**KIRKLEES METROPOLITAN COUNCIL
INVESTMENT & REGENERATION SERVICE**

DELEGATED DECISION TO DETERMINE PLANNING APPLICATIONS

Reference No:	2024/62/90613/W
Site Address:	Tenter Hill Cottage, Tenterhill Road, New Mill, Holmfirth, HD9 7LY
Description:	Erection of single storey extension
Recommending Officer:	Molly Storer

HOUSEHOLDER DELEGATED REPORT

Client: Jeremy Halstead & Jo Pearce
Project: Tenter Hill Cottage, New Mill, Holmfirth
Drawing: Scheme As Proposed

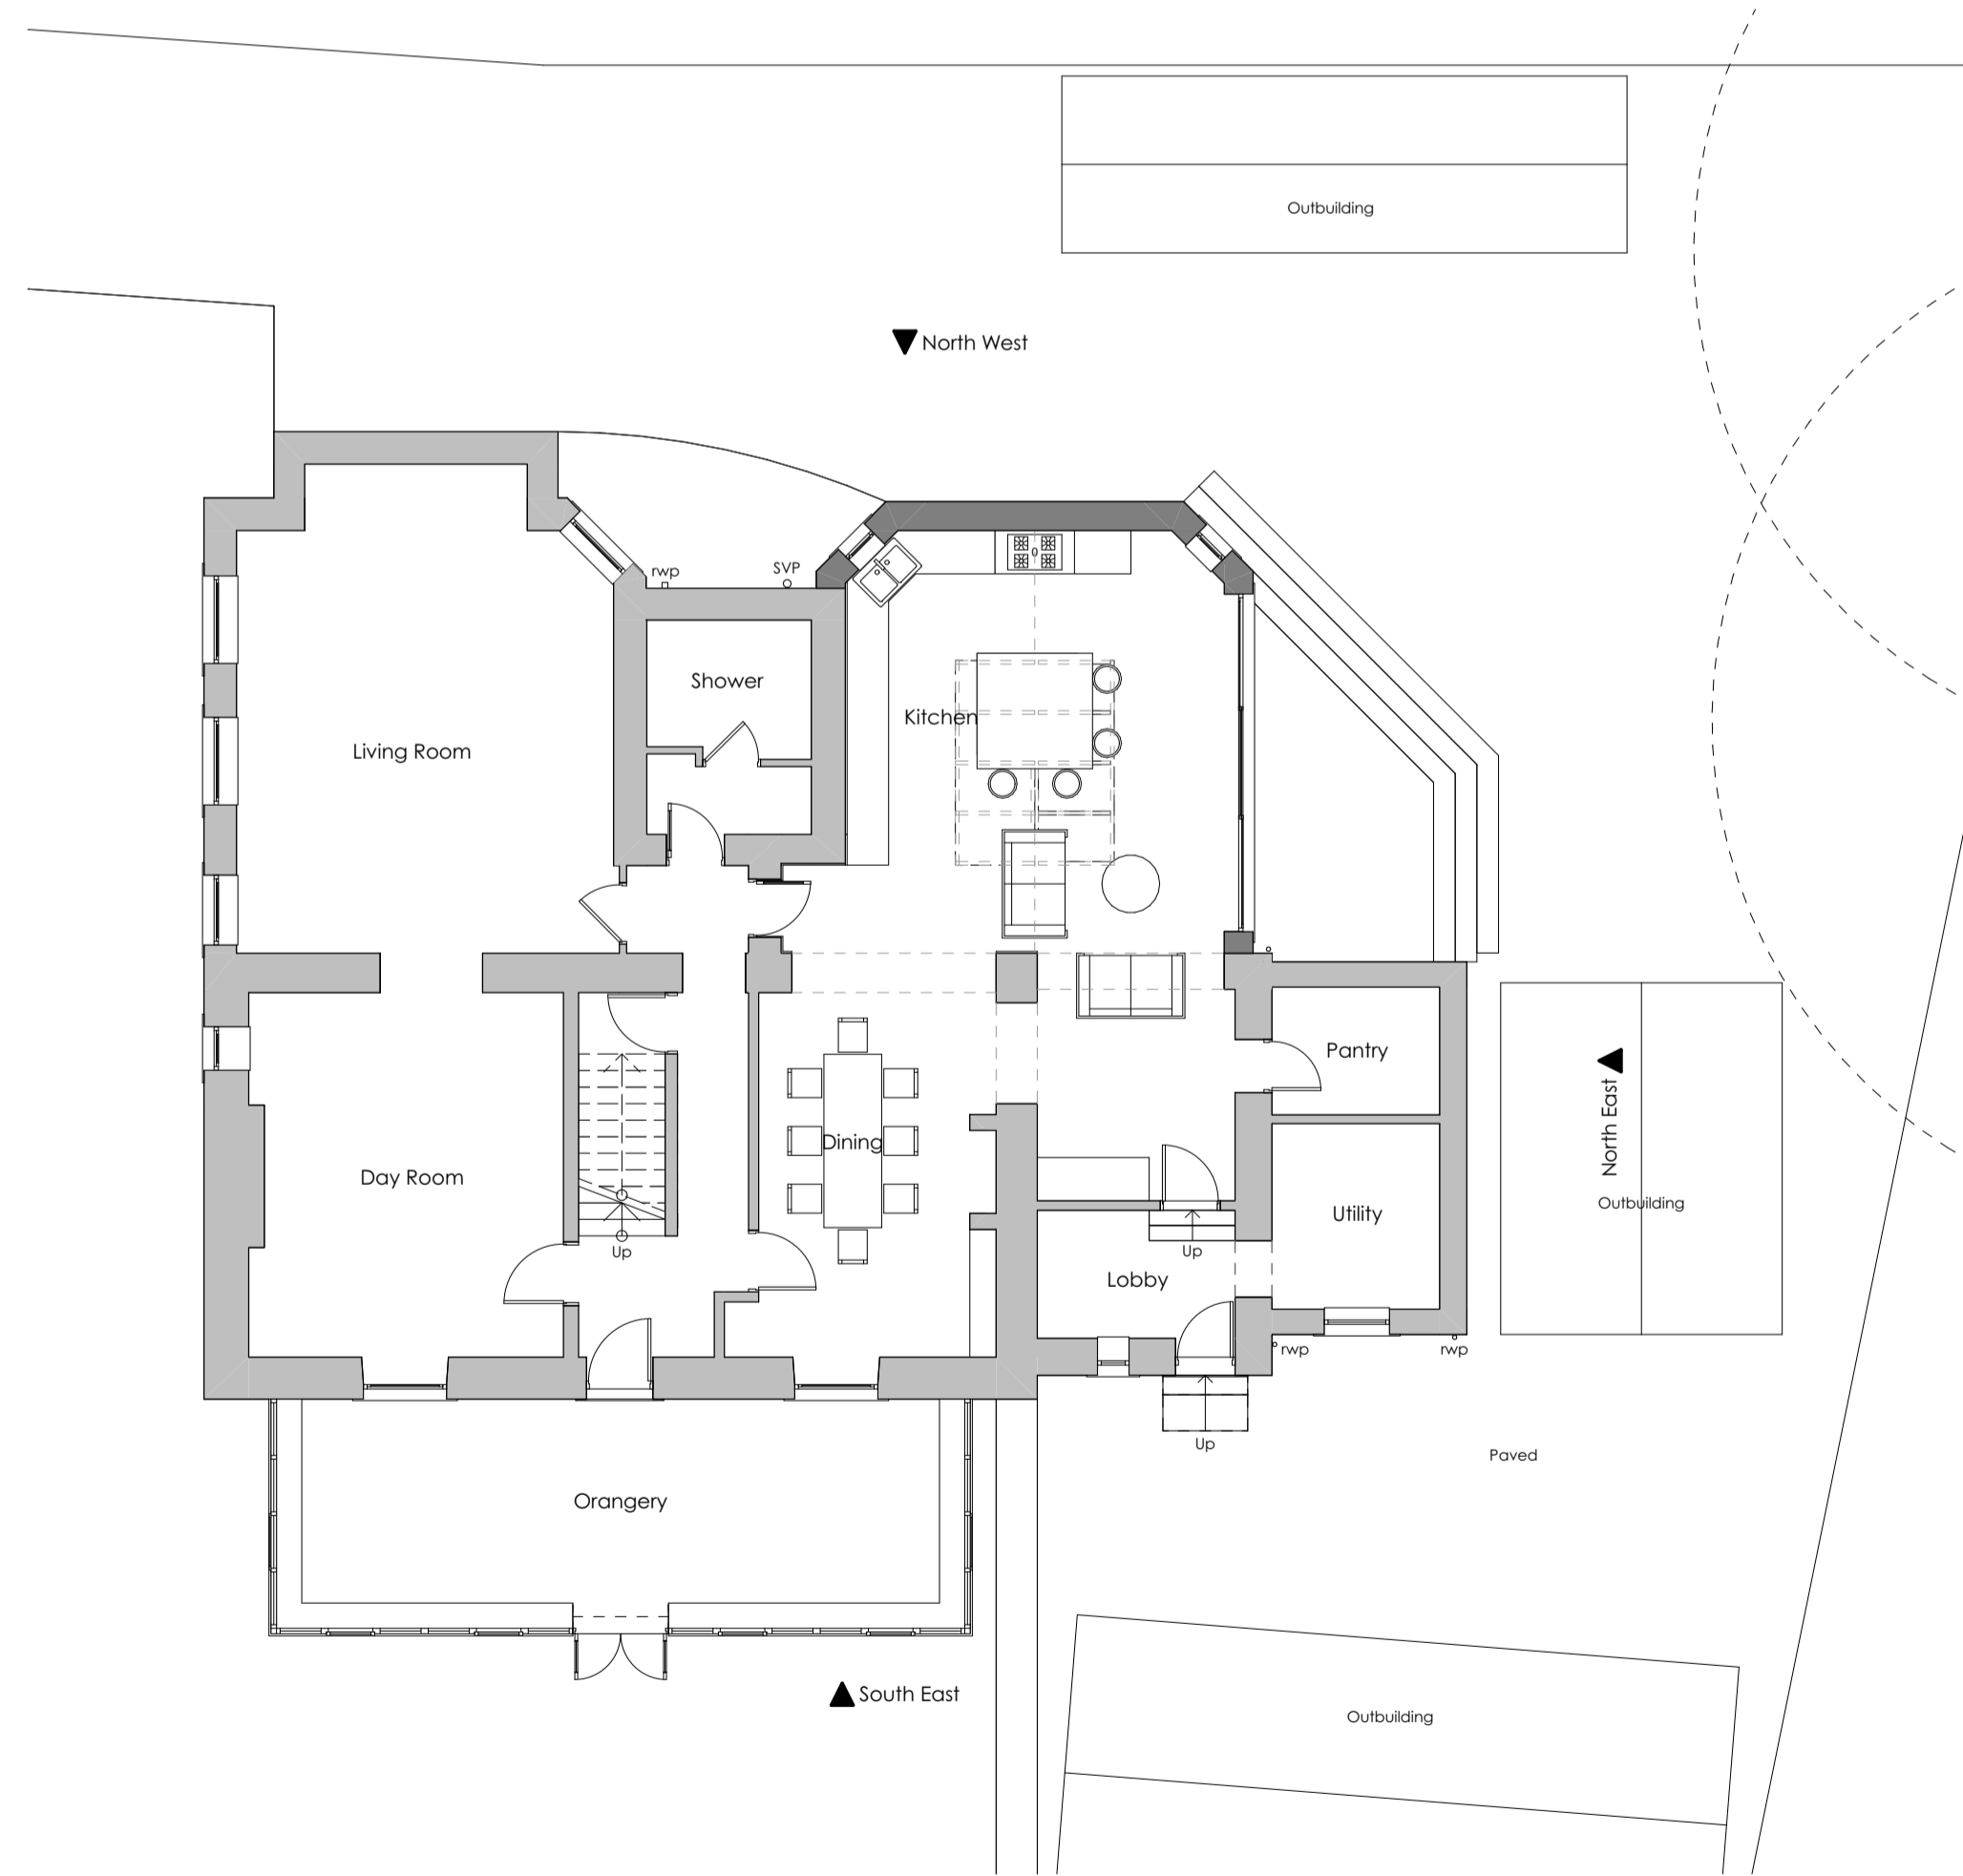
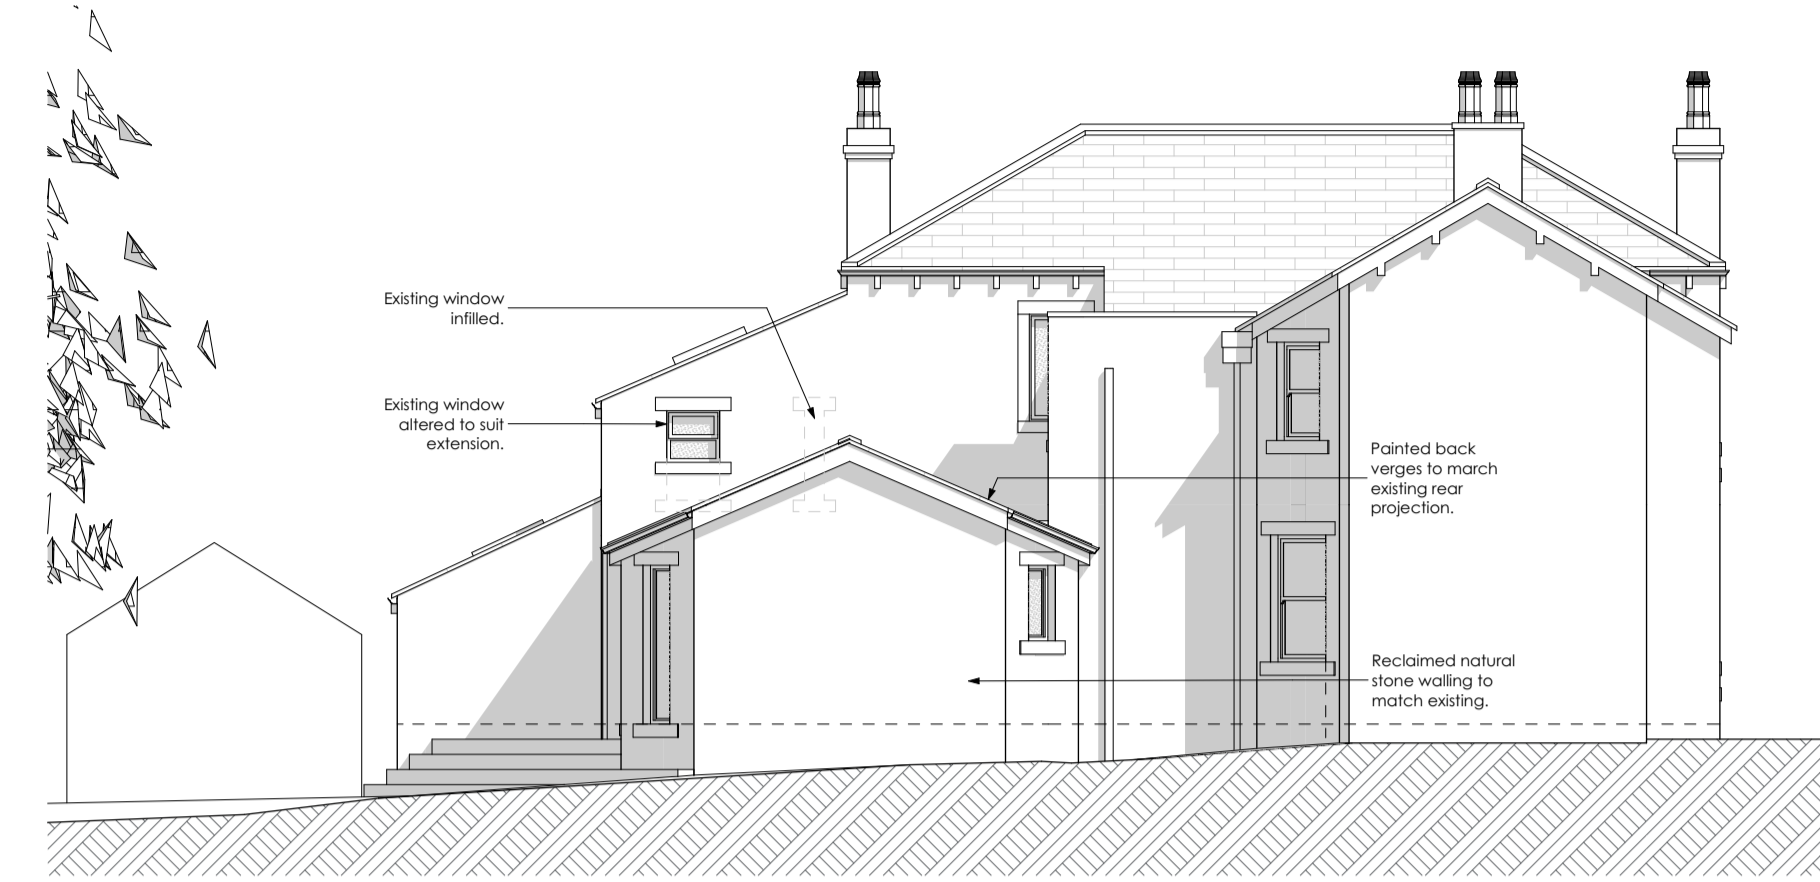
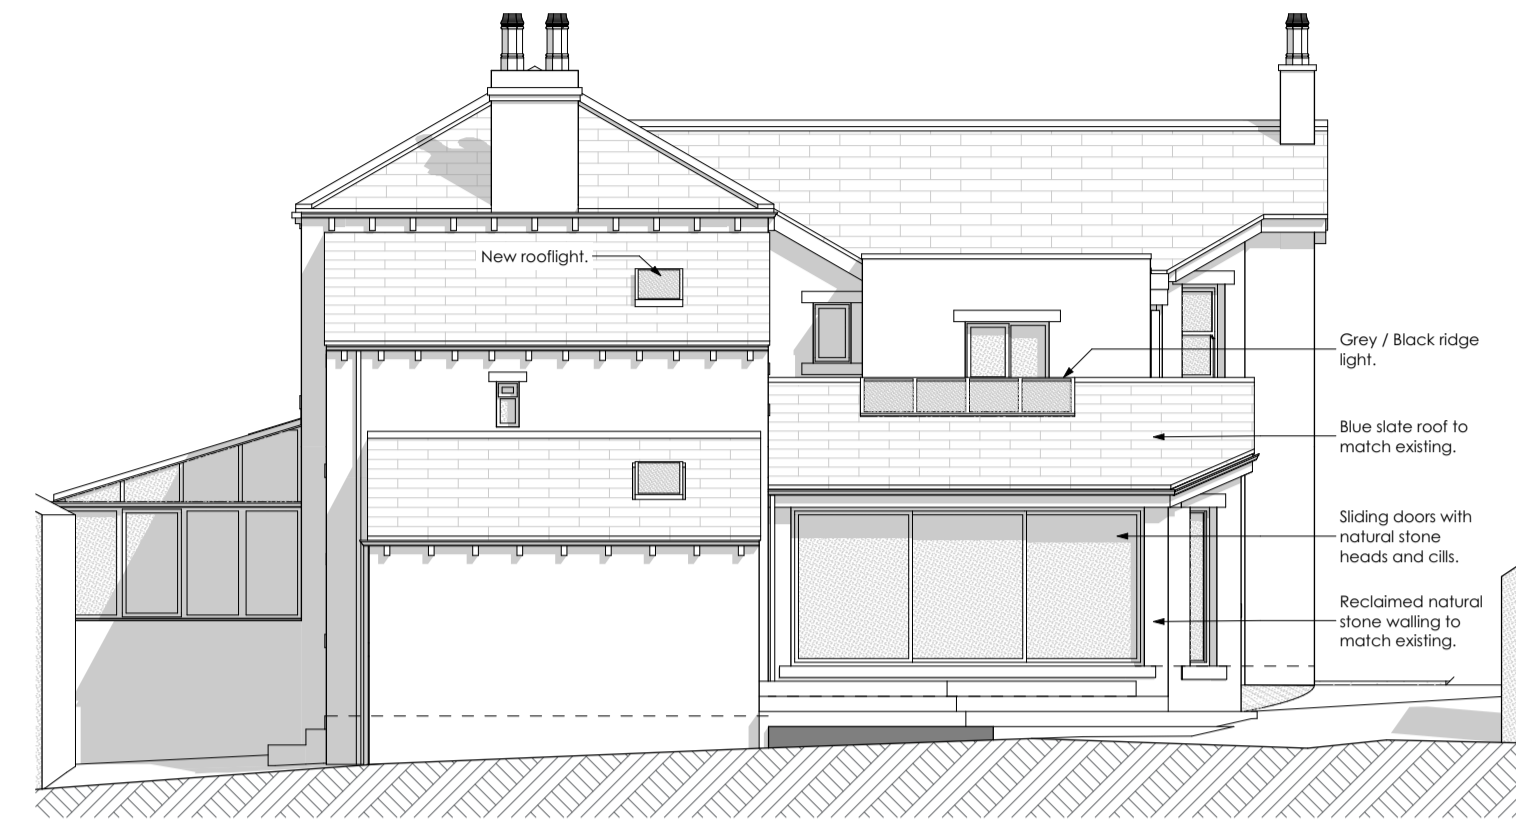
- 6.2 in length
- 5.5m in width
- 3.4m to the eaves
- 4.7m overall height – this is measured from the rear garden level the extension will be accessed via steps to the rear and will be set 0.7m above the garden level.

Single-storey rear extensions should:	<u>Yes - COMPLY</u>	<u>No - JUSTIFY</u>
be in keeping with the scale and style of the original house	Yes – the proposed materials of reclaimed natural stone for the walls and a blue slate roof will match that of the existing property. The gable roof design will harmonise with the original dwelling and due to the substantial footprint of the house the extension will be subservient in scale. It is acknowledged that there is a history of disparate additions to the property.	
not normally cover more than half the total area around the original house (including previous extensions and outbuildings)	Yes – it will not cover more than half the total area around the original house.	
not exceed 4 metres in height		No – due to the topography of the site the ground level slopes down slightly towards the rear garden. Therefore, the overall height when measured from the rear garden level is 4.7m however when measured from the ground level at which the front elevation is situated on the overall height measured 4m and is therefore considered acceptable.

not project out more than 4 metres from the		No – the extension would project 6.2m

rear wall of the original house for detached houses		however this is considered acceptable as the extension will not project materially further than existing development on the rear, northeast elevation.
where they exceed 3m in length the eaves height should generally not exceed 2.5 meters		No – the extension exceeds 3m in length and 2.5m to the eaves. However due to the positioning of the extension it will be screened from public vantage points and will still be subservient to the original dwelling house.
retain a gap of at least 1 metre from a property boundary, such as a wall, fence or hedge	Yes – a gap of 5m will be retained to the neighbours boundary

Impact on the Local character and street scene	<ul style="list-style-type: none"> • KDP1 of the SPD • Policy LP24 Design (a) and (c) of the KLP • Chapter 12 NPPF • Policy 1 & 2 of the HVNDP 	Single storey extension located to the rear which will be screened by the original house and not be overtly visible from the public view. The extension will be constructed from natural stone which is favoured on the HVNDP for this area.	✓
Impact on original house	<ul style="list-style-type: none"> • KDP2 of the SPD • Policy LP24 Design (c) and (d) of the KLP • Chapter 12 of the NPPF • Policy 1 & 2 of the HVNDP 	The single-storey rear extension would be constructed from natural stone to match the host property, would not protrude further than existing development to the rear and would be subservient with the host. It is noted it would add yet another roof form and style, but along this elevation this is not critical to the scheme.	✓

Height, scale and massing	<ul style="list-style-type: none"> • KDP 1 and 2 of the SPD • Policy LP24 Design (a), (c) and (d) of the KLP • Chapter 12 of the NPPF • Policy 1 & 2 of the HVNDP 	As above.	✓
Facing materials and detailing	<ul style="list-style-type: none"> • KDP 9 of the SPD • Policy LP24 Design (d) (iii) of the KLP • Chapter 12 of the NPPF • Policy 1 & 2 of the HVNDP 	Facing materials and simple detailing would harmonise acceptably with the original host and the previous organic additions to it.	✓
Roof style	<ul style="list-style-type: none"> • KDP 1 and 2 of the SPD • Policy LP24 Design (a), (c) 	Gable roof to match that of roof form on the northwest side elevation.	✓

<ul style="list-style-type: none"> and (d) of the KLP • Chapter 12 of the NPPF • Policy 1 & 2 of the HVNDP 		
Window proportions	<ul style="list-style-type: none"> • KDP 1 and 2 of the SPD • Policy LP24 Design (a), (c) and (d) of the KLP • Chapter 12 of the NPPF • Policy 1 & 2 of the HVNDP 	While the glazing to the rear would be larger with the introduction of large sliding doors to the ground floor this would be of low visual impact to the street scene and be deemed therefore acceptable. There will be two small single panel windows on the ground floor of the northwest elevation and an existing window moved altered to suit the extension these will be small and will not affect neighbouring properties.	✓
Accessibility for all users	<ul style="list-style-type: none"> • KDP 17 of the SPD • Policy LP24 Design (f) • Chapter 12 of the NPPF • Policy 1 & 2 of the HVNDP 	Private domestic extension which would not change the existing access into / around the property.	✓

3. The external walls and roof hereby approved shall in all respects match those used in the construction of the existing building and be retained thereafter.
